Urban Design Review

ATC Royal Randwick Racecourse – Hotel Development

October 2013

NORTH ELEVATION

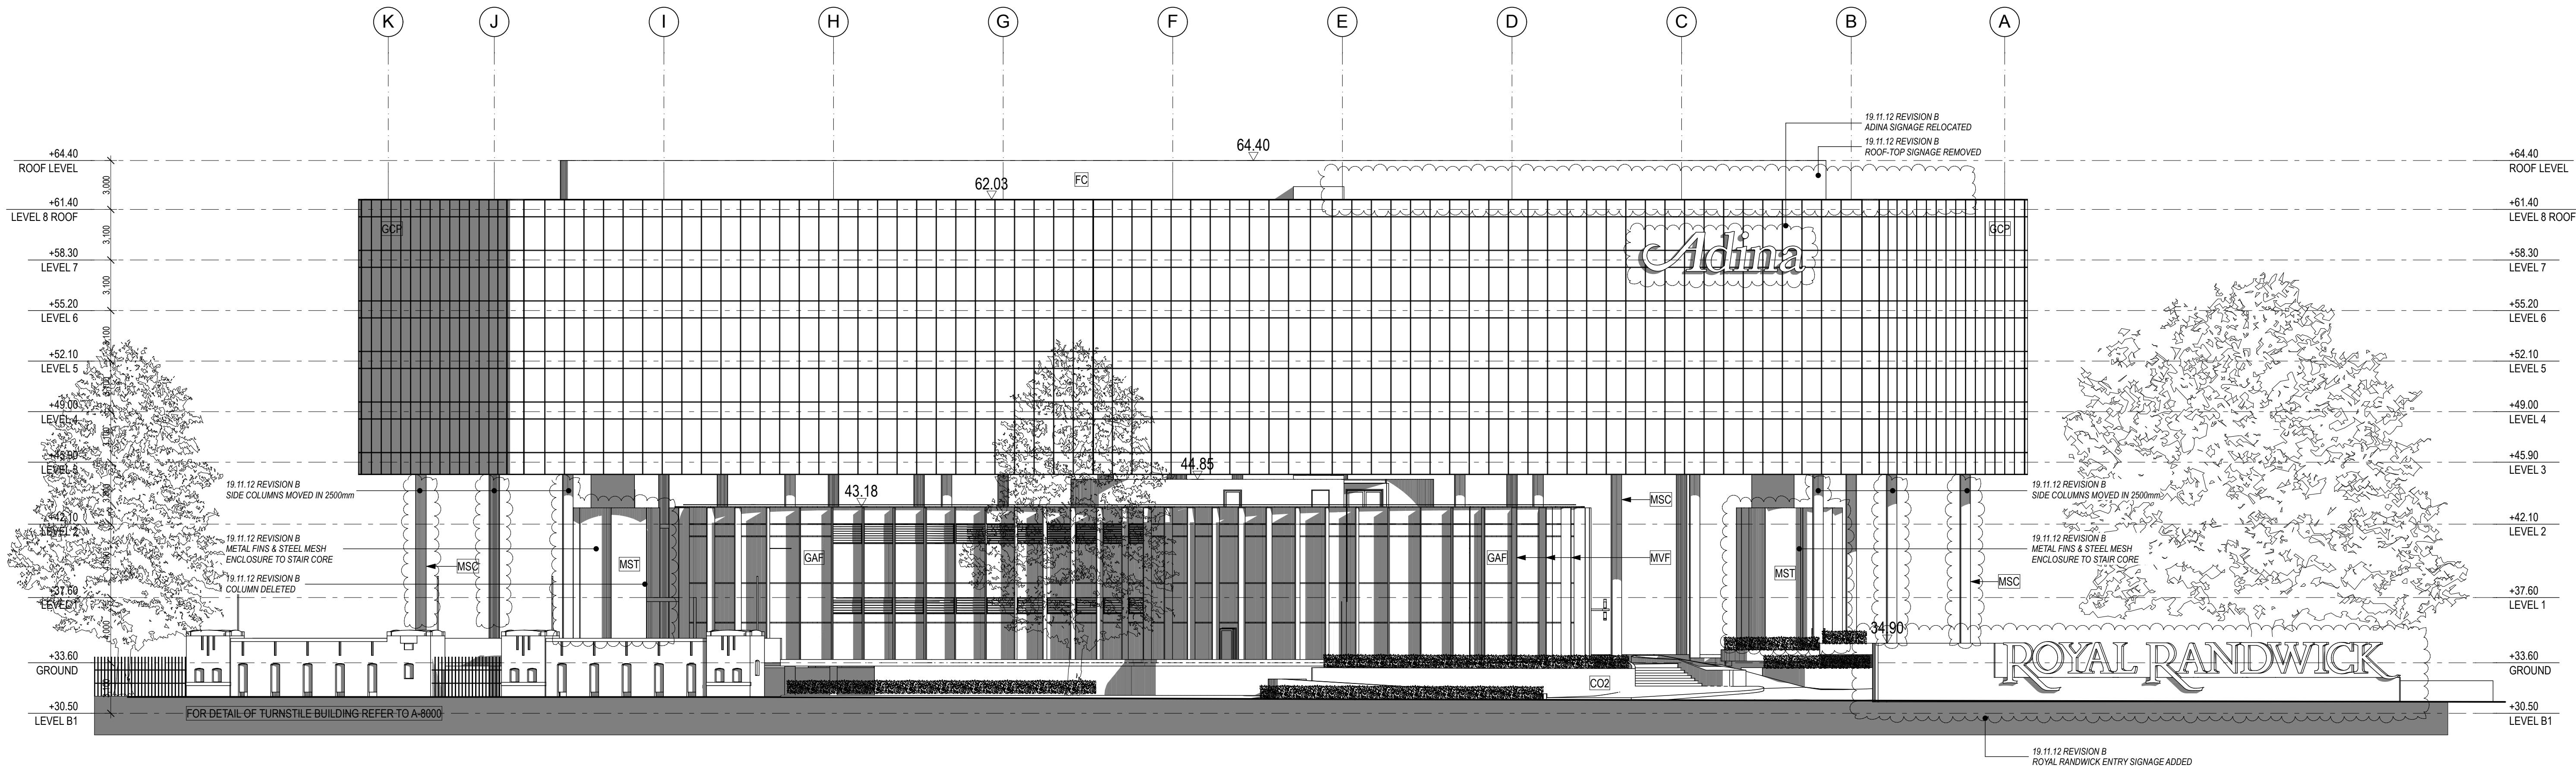
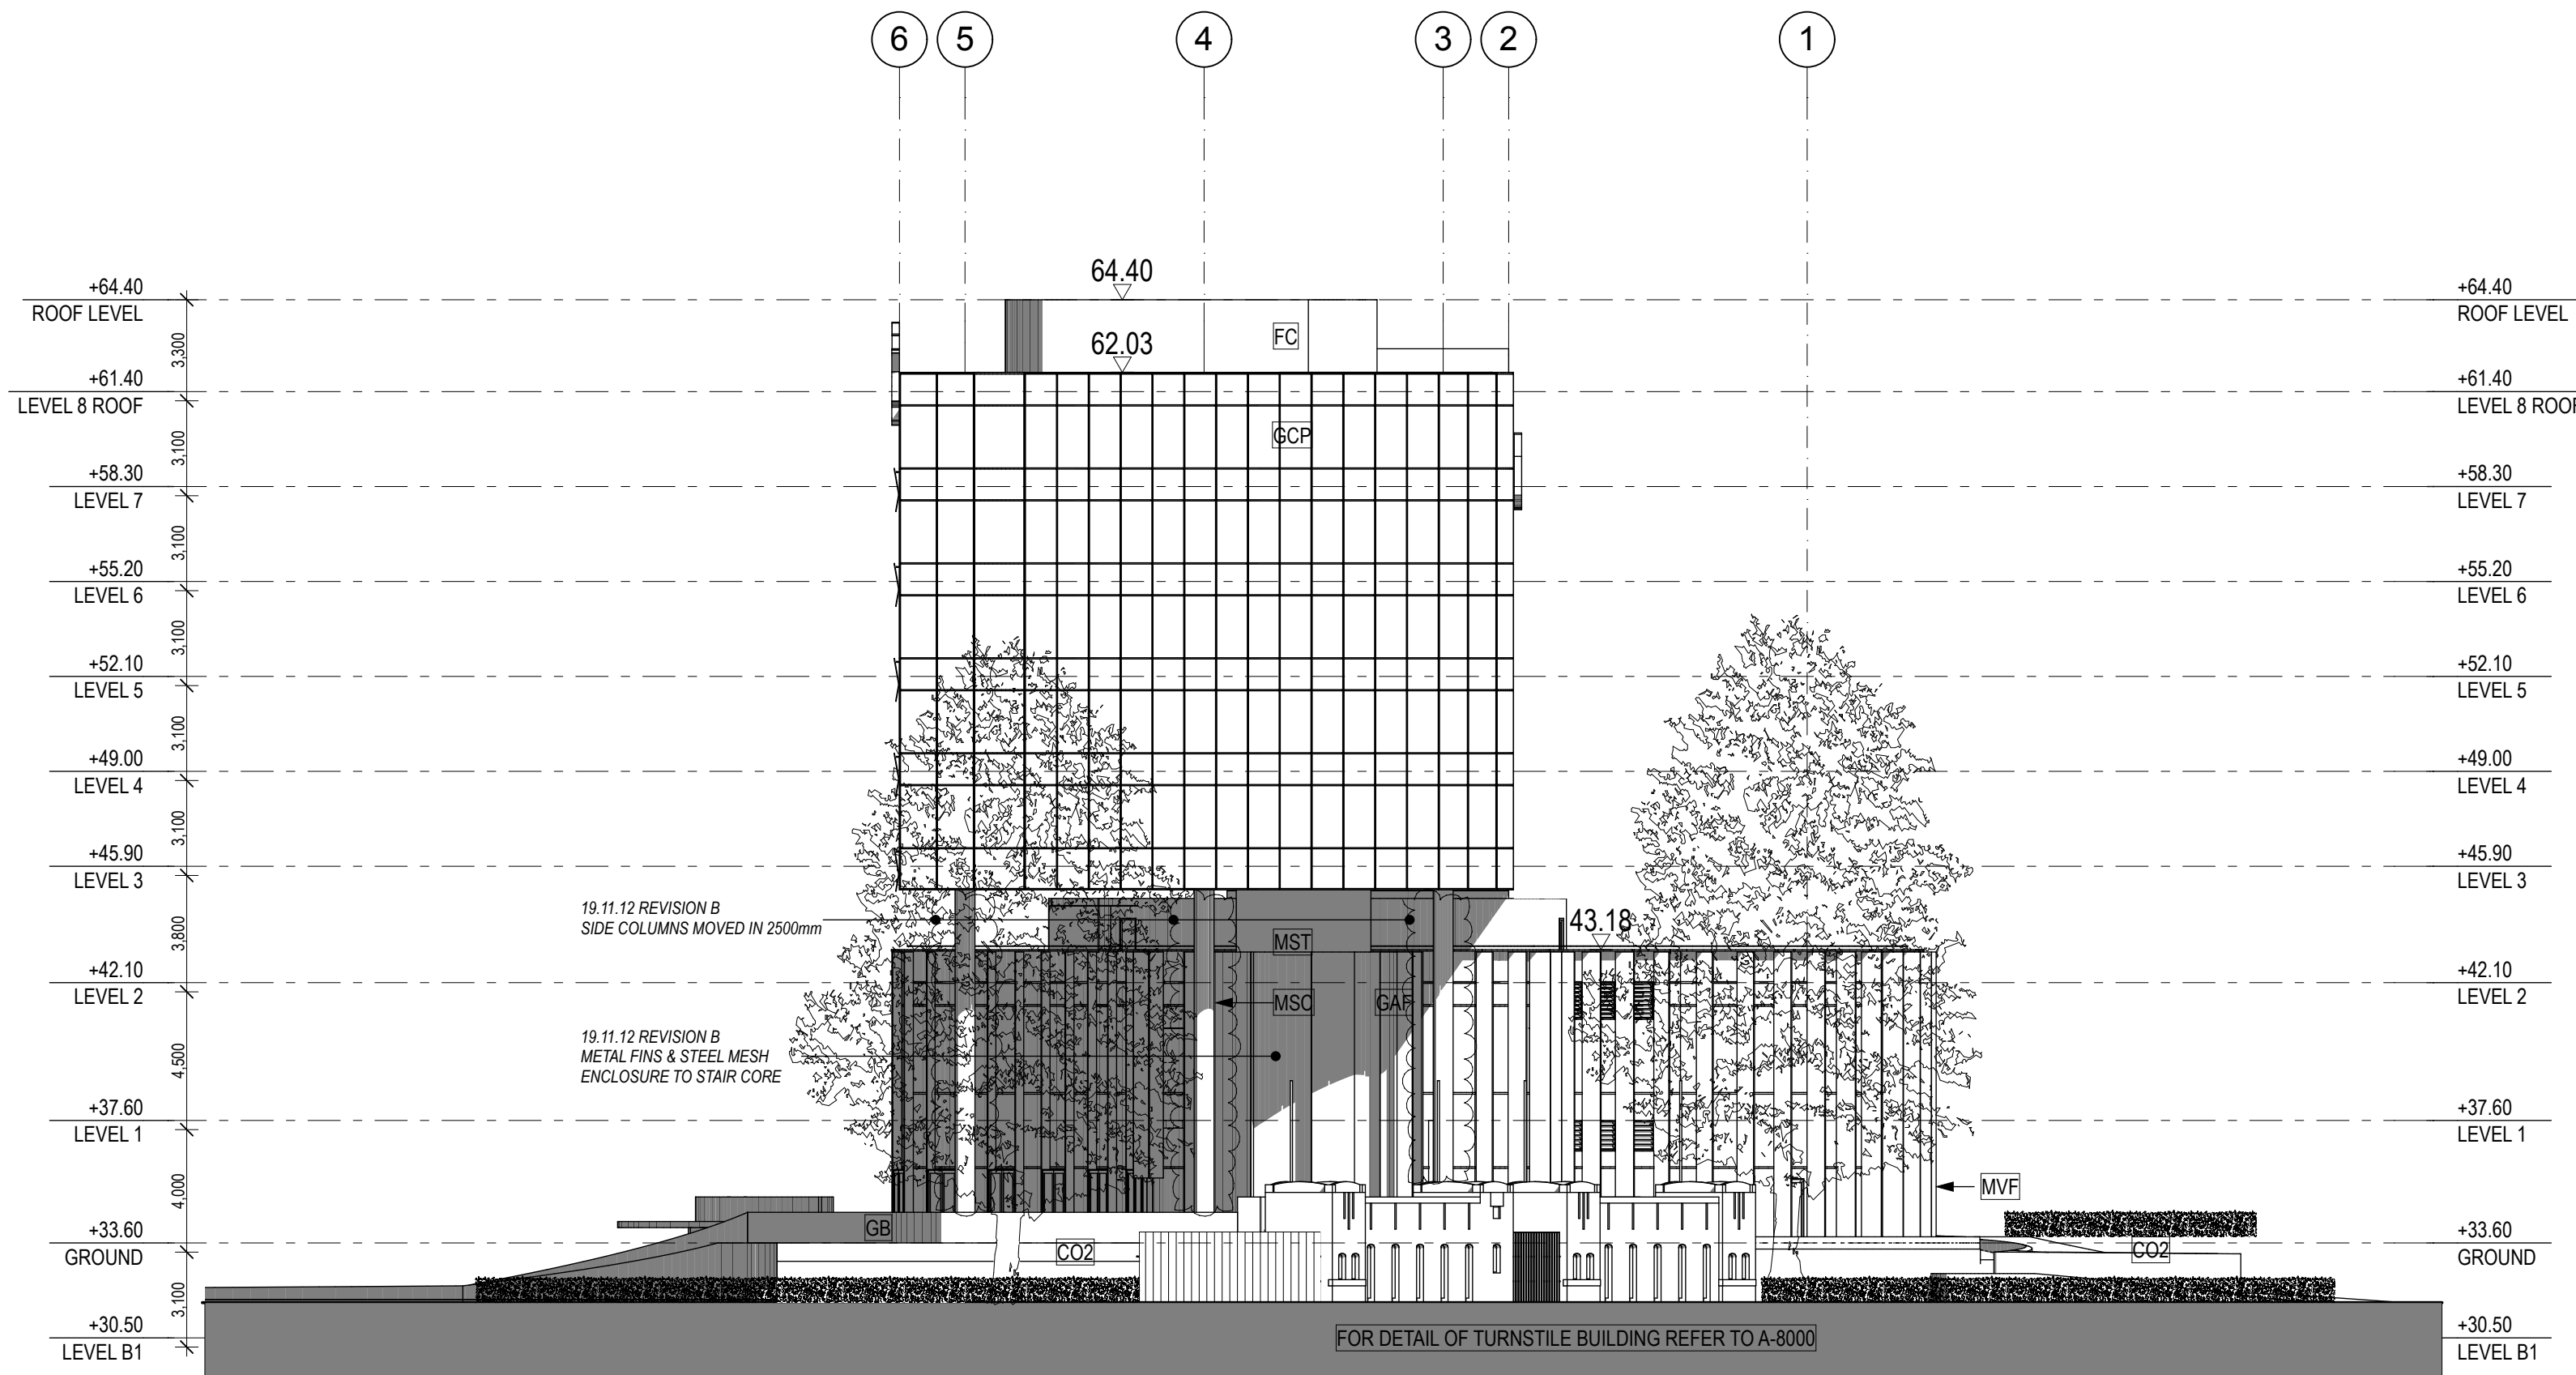
- The design of the underside of the hotel structure and the columns with staircases, should be designed in a more sculptural form;
- A lack of articulation on the front facade;
- Unsatisfactory art work on the front facade lacking a distinctive and transcending style without the visual interest of a landmark development;
- The general bulk and scale and disproportionate building elements;
- The relation in height and scale to the TAFE building and the new Grand Stand, which were thought to be unrepresentative of the general scale and character of the area;
- The odd realignment of building components;

DRAWING NO A-9001	REVISION B

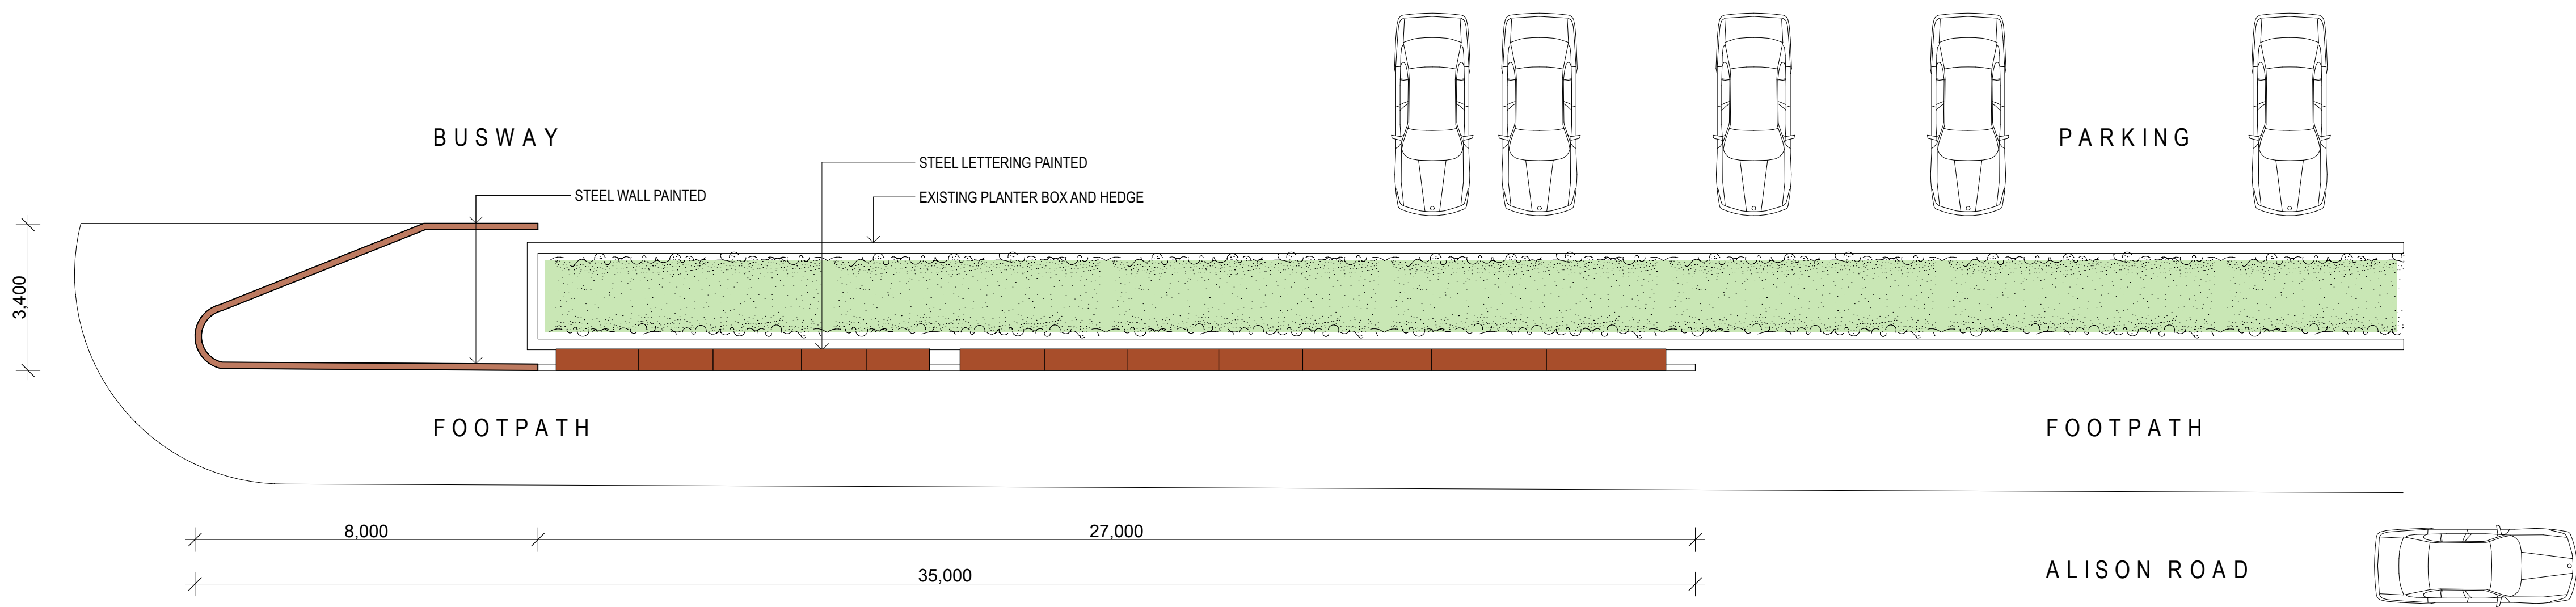
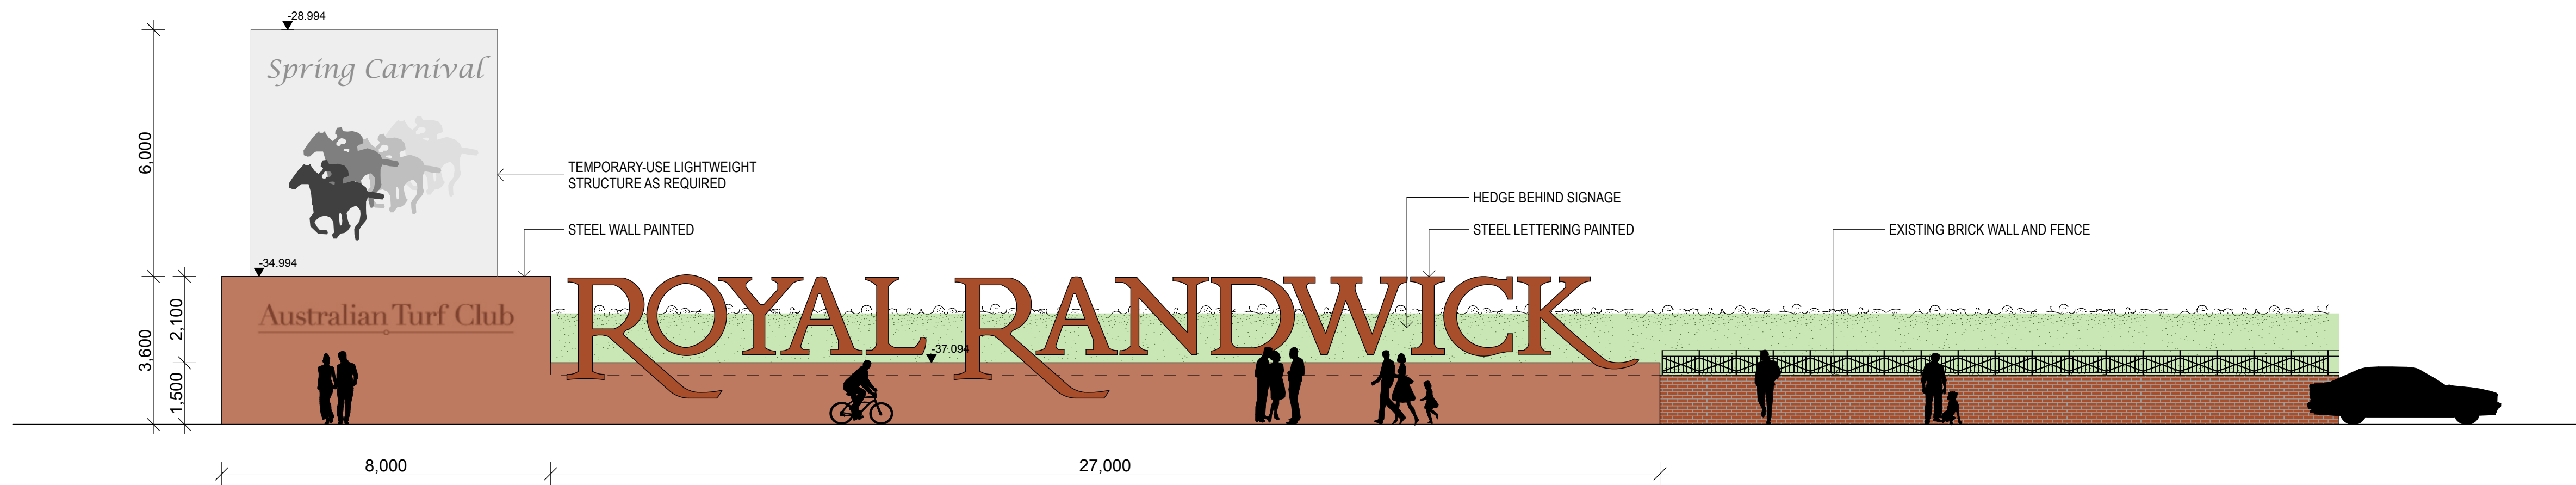
The proposal included a corporate logo on the Alison Road and racecourse facades. The signage was internally illuminated displaying the name 'Adina' with a maximum height of 3m and 12m in length next to the words 'Royal Randwick' which would also be 3m high and 26m wide. The signage extended beyond the plant by 0.89m.

- The location of signage above the façade not being compliant with the DCP and
- A potential wind tunnel effect at the third level terrace area.
- The failure to retain the Fig tree, replanting and replacement with other;
